KIRKLEES METROPOLITAN COUNCIL INVESTMENT & REGENERATION SERVICE

DELEGATED DECISION TO DETERMINE APPLICATIONS FOR CONSENT, AGREEMENT OR APPROVAL REQUIRED BY CONDITION

Reference No:	2023/44/90773/W
Site Address:	Land at, Penistone Road, Fenay Bridge, Huddersfield, HD8 0AW
Description:	Discharge of conditions 4 (highway works), 5 (right turn lane), 6 (internal adoptable estate roads), 8 (retaining walls/structures), 9 (surface water), 10 (highway survey), 11 (surface water and land drainage), 12 (storm events), 13 (temporary surface water drainage), 15 (archaeological evaluation), 16 (levels), 18 (Biodiversity Net Gain Assessment) and 19 (EDS) of previous permission 2020/90725 for erection of 68 dwellings with associated access, parking and open space (revised plans)
Recommending Officer:	Nick Hirst

DECISION – Discharge of Conditions – Split Decision

Section A-AA

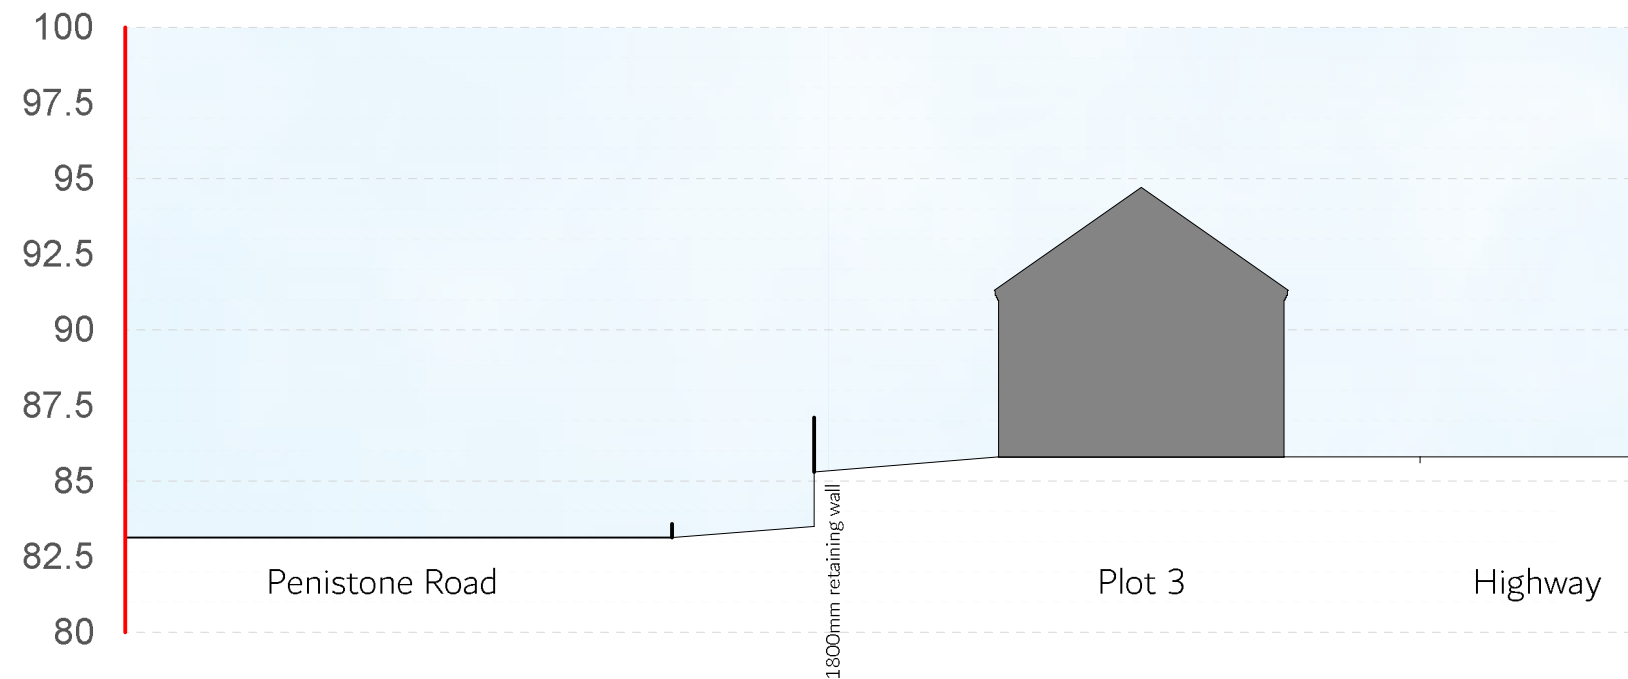
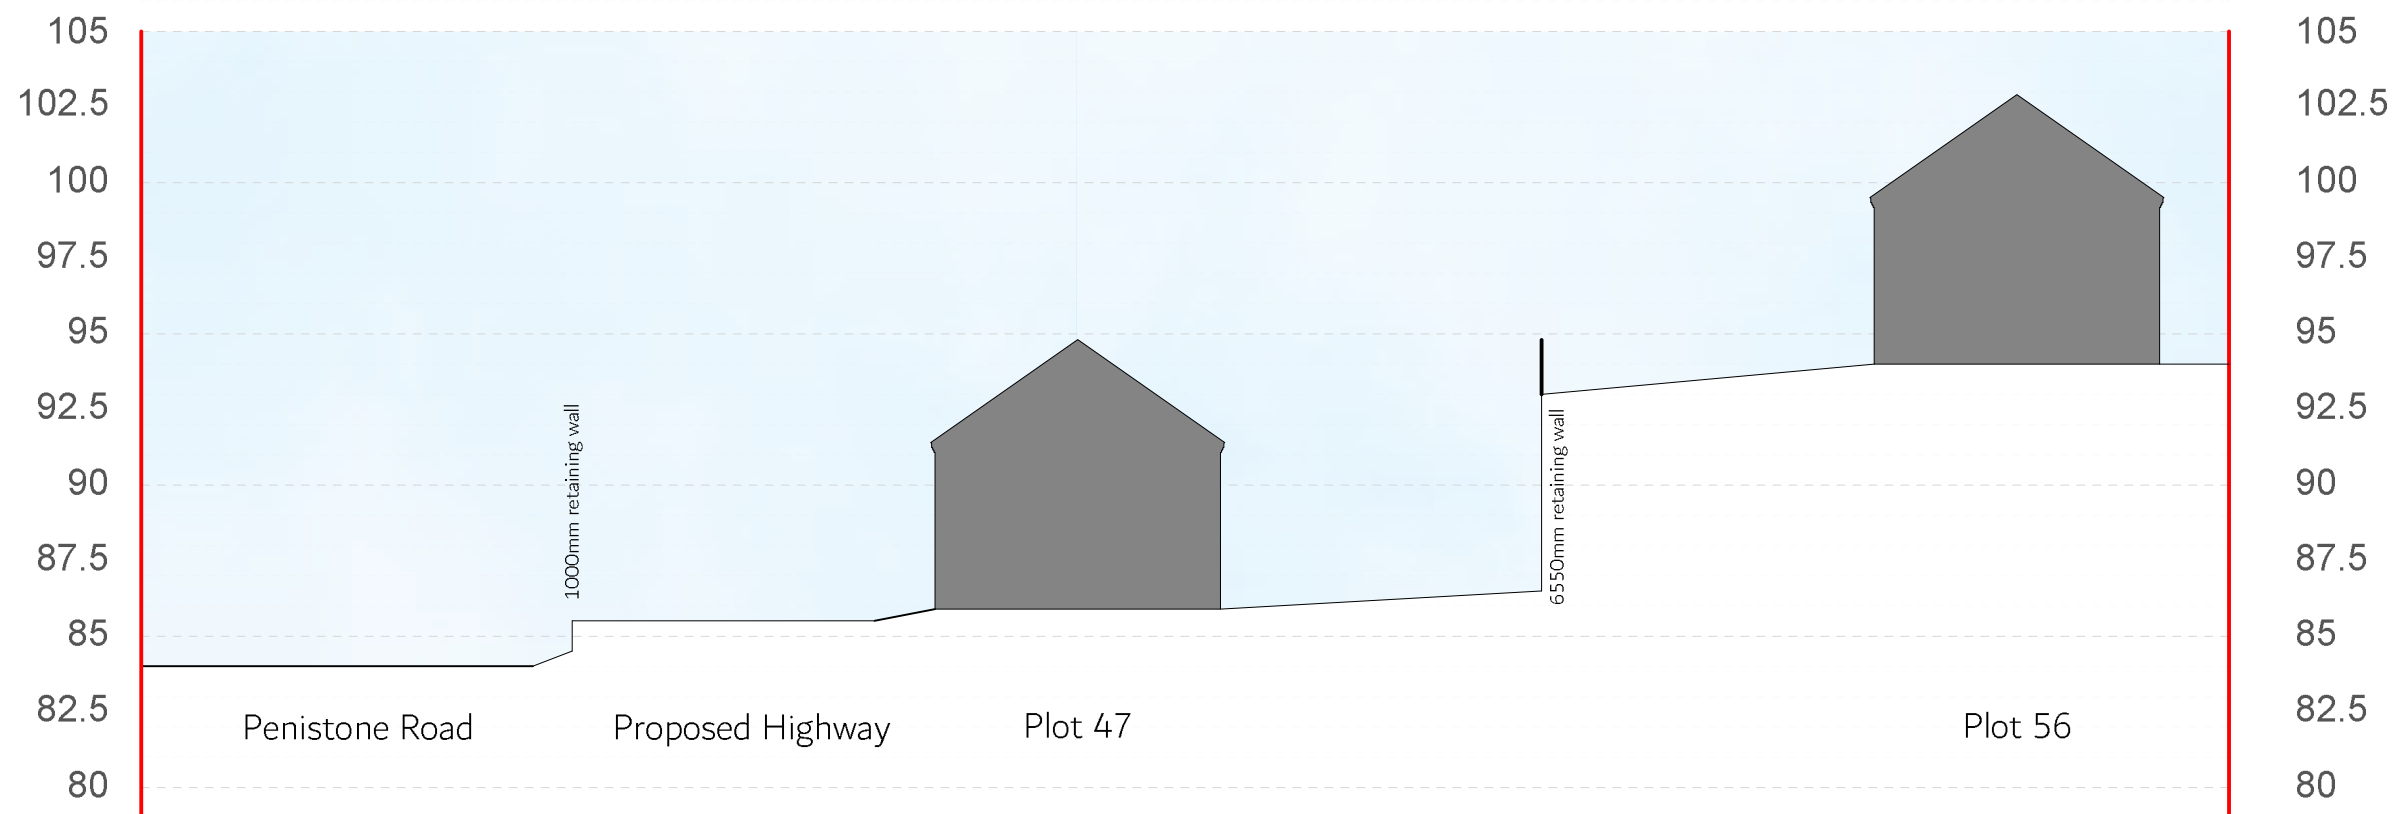
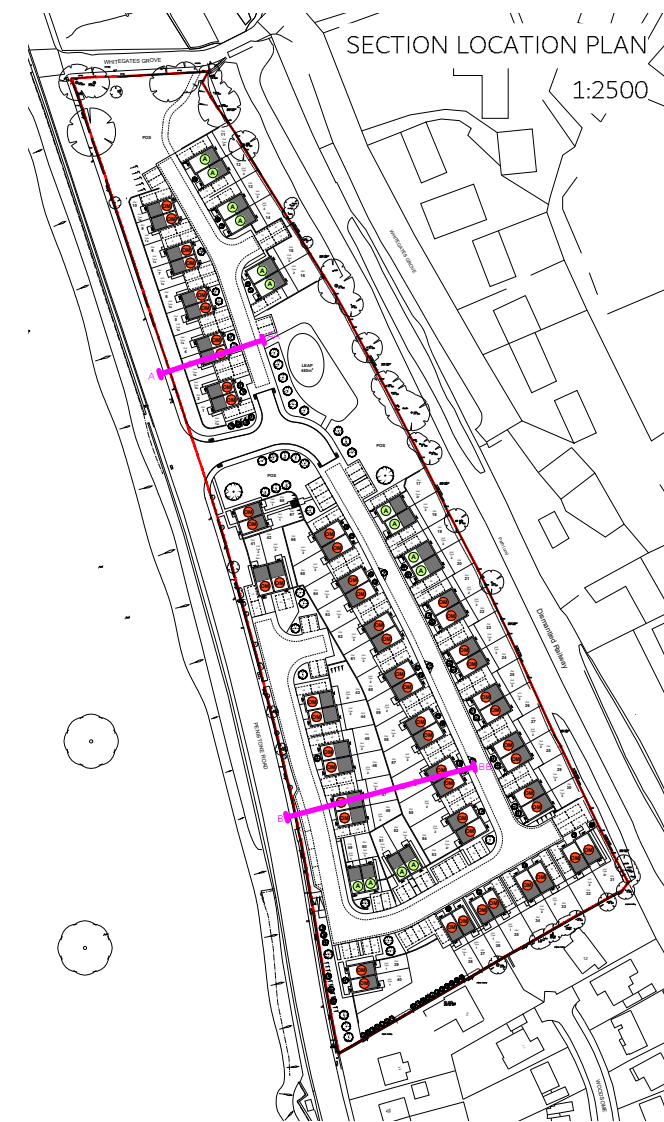
While a site plan showing the retaining walls and general cross-sectional information has been provided, the information does not amount to the required 'design and construction details' required to resolve this condition.
